Our Ref: ABP-301908-18

Re: Greater Dublin Drainage Project consisting of a new wastewater treatment plant, sludge hub centre, orbital sewer, outfall pipeline and regional biosolids storage facility
Townlands of Clonshagh, Dubber and Newtown, County Fingal and Dublin City

REF: Greater Dublin Drainage Project **Case reference: PL06F.301908**

I wish to object to the granting of permission for the Greater Dublin Drainage Project.

MARINE RISER & DIFFUSER SYSTEM
Scale 1:100

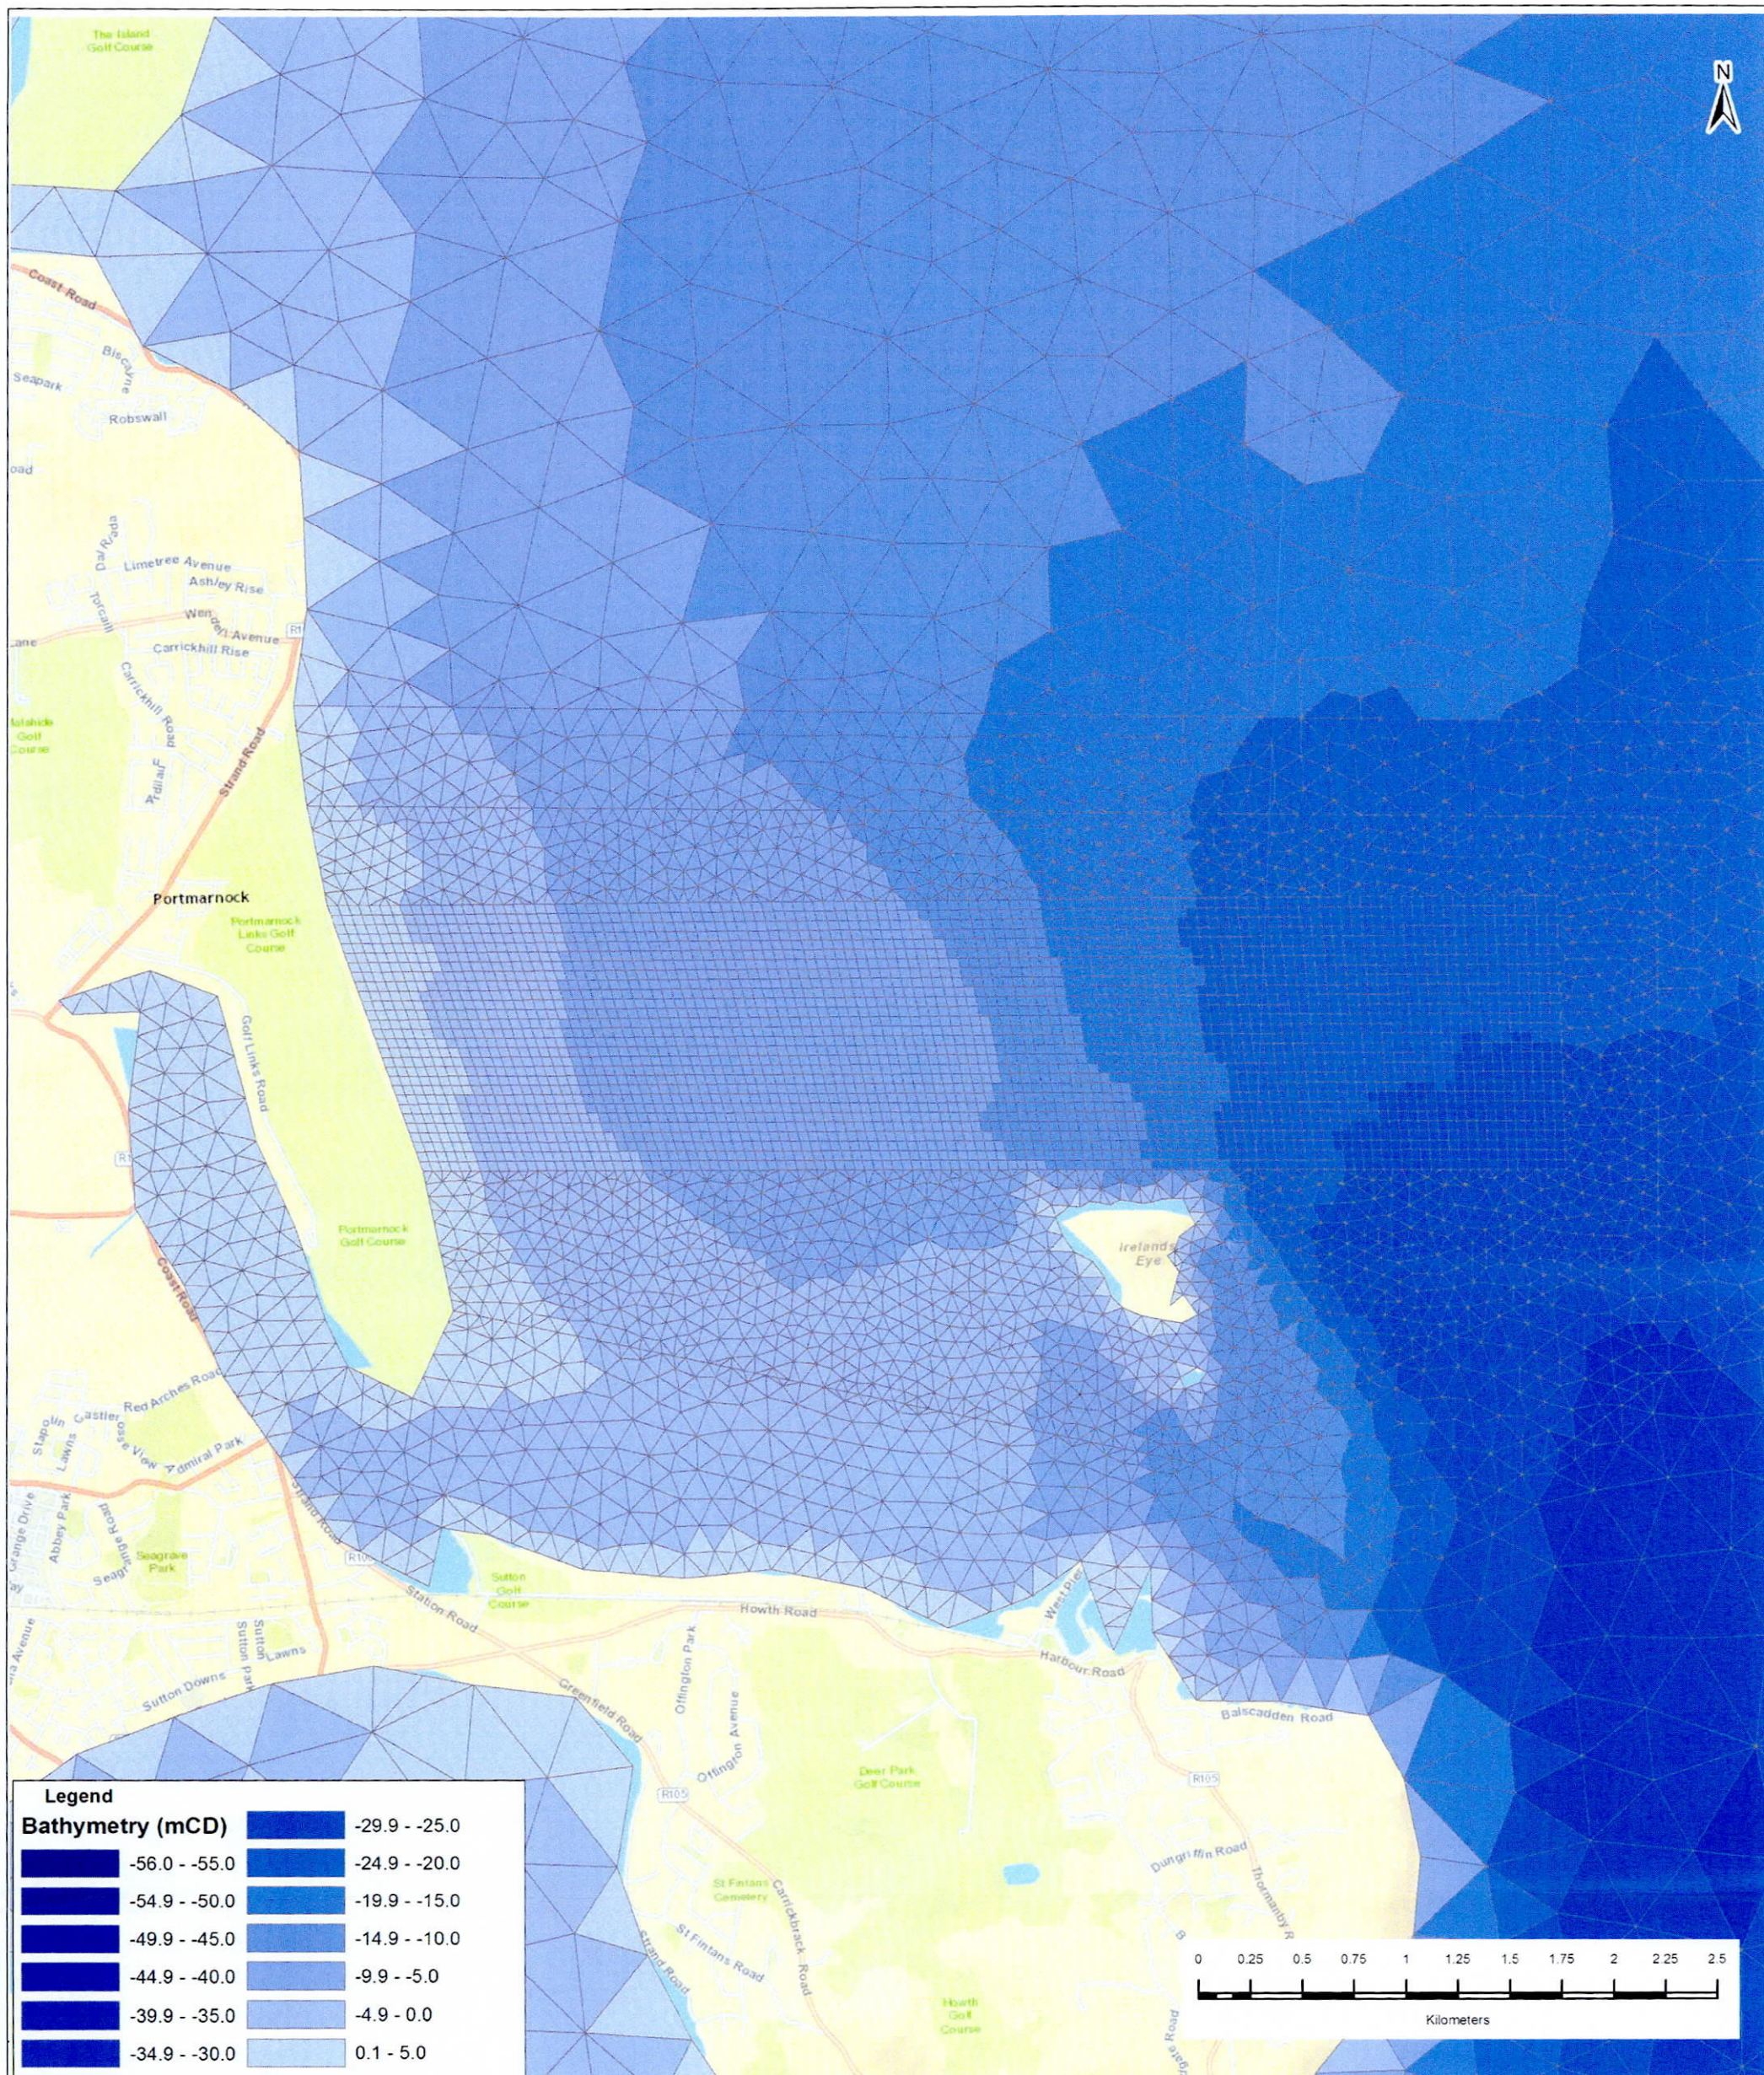
- 2-7 Marine Diffuser: A photo of a dalek like outfall diffuser is shown with small diameter outlets. They appear to be totally insufficient to allow the volume of liquid to discharge. Is there more detailing to be done on the discharge / diffuser area?
